2021/0785

Description: Replacement of existing building with new dwelling and associated works (Amended Access and Redline)

Site Address: Heald Head Cottage, North Lane, Cawthorne, Barnsley, S75 4AQ

TRACK
DRG 3

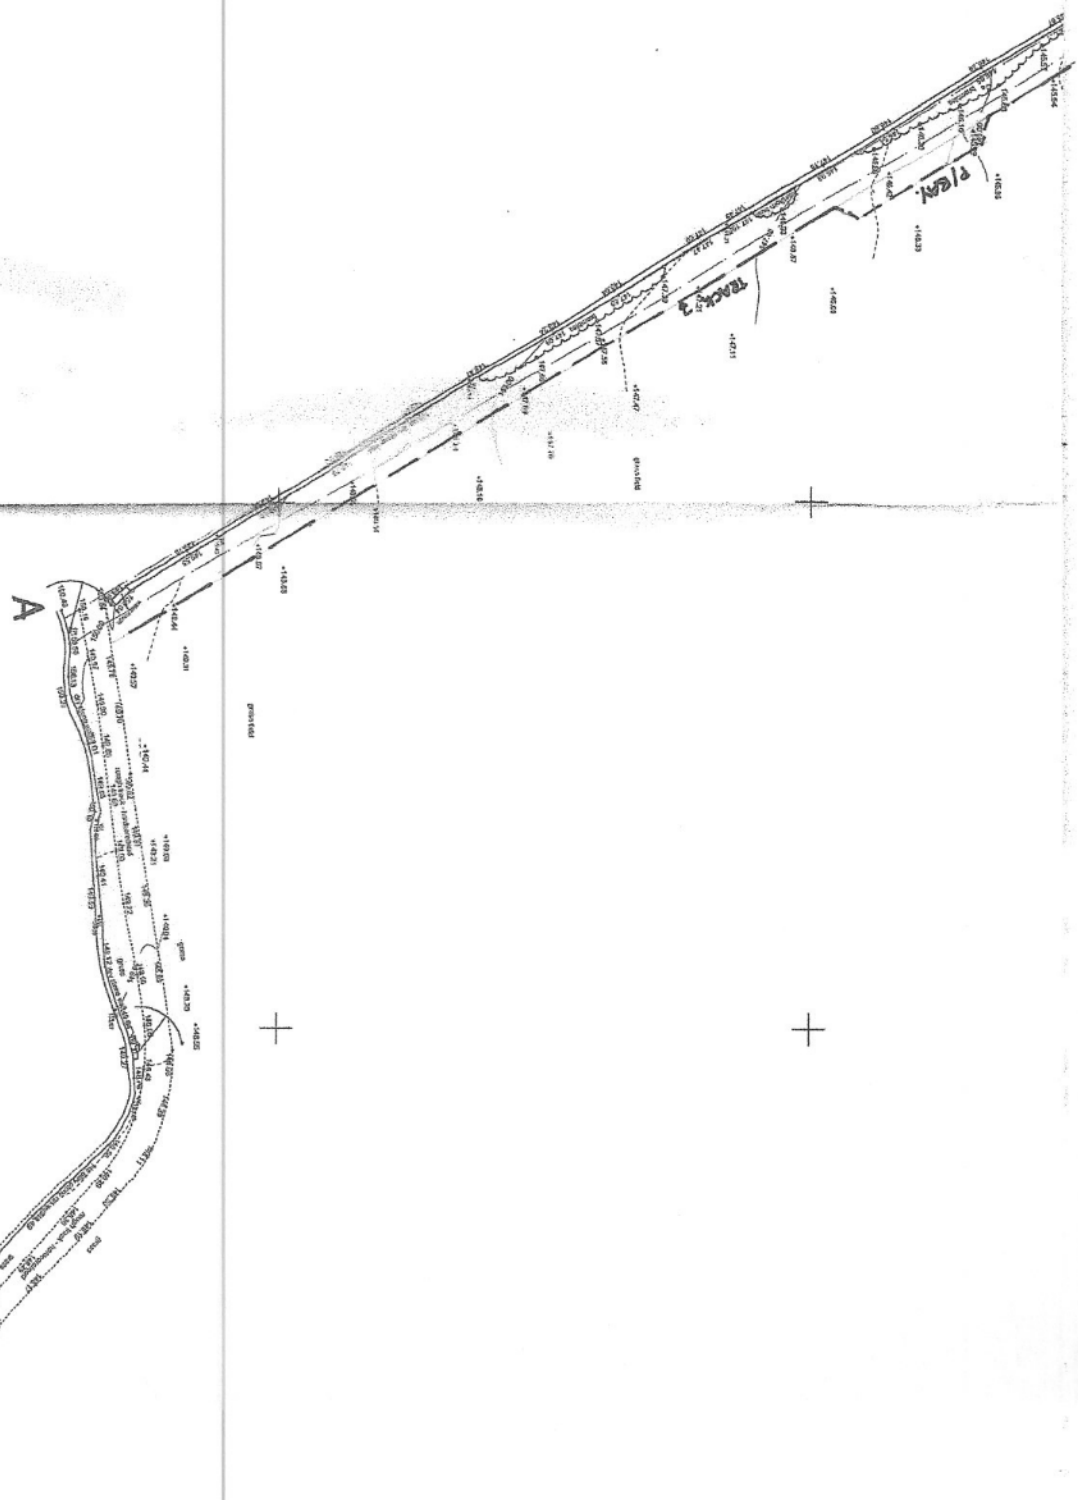
During construction, all PROW should remain open whenever safely possible. Where this is not possible, such as when the access track is being resurfaced, a formal temporary closure order will be required. However, the design shows a cattle grid and PROW objects to this as it is not lawful to have a cattle grid across the full width of a footpath or bridleway.

In addition to the above, the width of the route may need to exceed 3-3.5m in order to accommodate both vehicular access and the PROW. This will increase the impact. As will the proposed cattle grid which cannot be supported across a PROW without a separate route around it for pedestrians.

TRACK
DRG 2

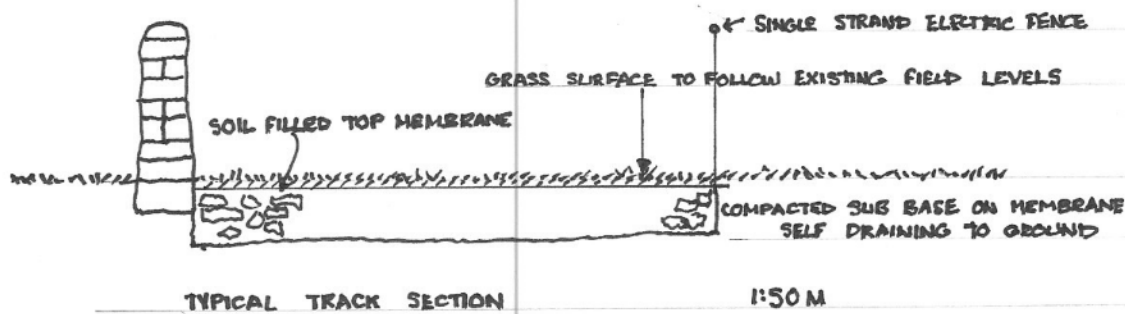
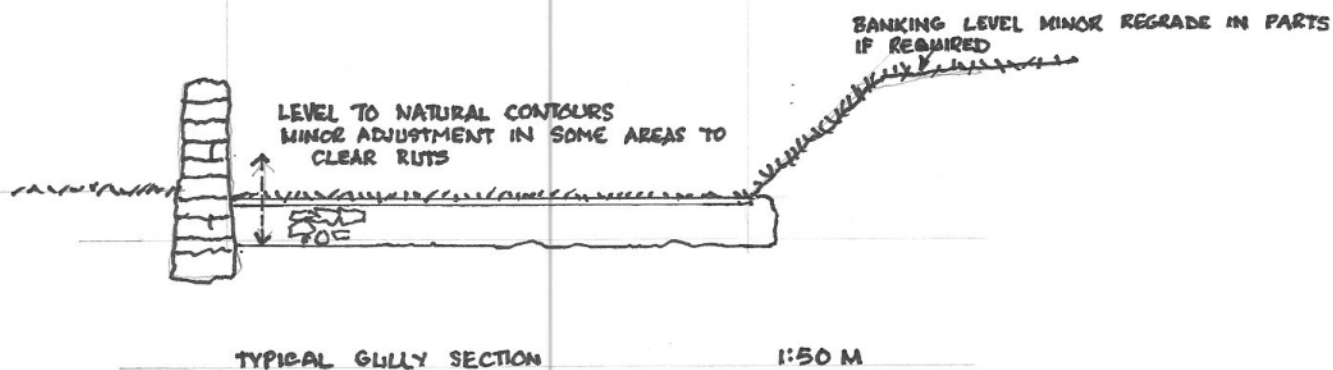
Details should also be provided about the width of the track and the proposed electric fence. The applicant should demonstrate that a sufficient width has been provided for pedestrians and cars to pass safely without any danger or interference from the electric fence. If at any time the electric fence is considered to provide a danger to the public, enforcement action may be taken.

A suitable vehicular access is required. The route for this has been amended during the course of the application to cross fields from Pashley Green Farm to the south east. This route is circa 560m in length and, other than the existing access to the farm, which is circa 200m in length, it is currently a PROW across the fields with no surfacing. The applicant proposes to construct an access using compacted subbase with a top membrane and grass surface. This would be 3-3.5m in width with

one passing place. A topographical survey of the route has been provided which shows that although much of the route is relatively level, works will be required to create a suitably flat access. This is most pronounced at the northern end, where the access joins the woodland adjacent the proposed house. The PROW slopes down here, into a cut-in with steep sides. It then takes a right turn into the site; levels here are more complex and work will be required to achieve an access suitable for vehicles. The detail provided is not clear regarding the degree of leveling required with the agent maintaining this will be minimal. However, the survey shows that the levels vary by 2m or more and that there are a number of trees located on or adjacent to the route which will be affected; no tree survey has been forthcoming and no impact assessment. Despite the limited detailed information, it is clear from site visits and the topographical survey that the proposed track would have a visual and spatial impact on openness as would the increased activity associated with its use. Although grassed, the route would be noticeable as a change in levels and because of the impact on, and likely clearance of, trees. The latter also opening up views of the building which are currently screened.
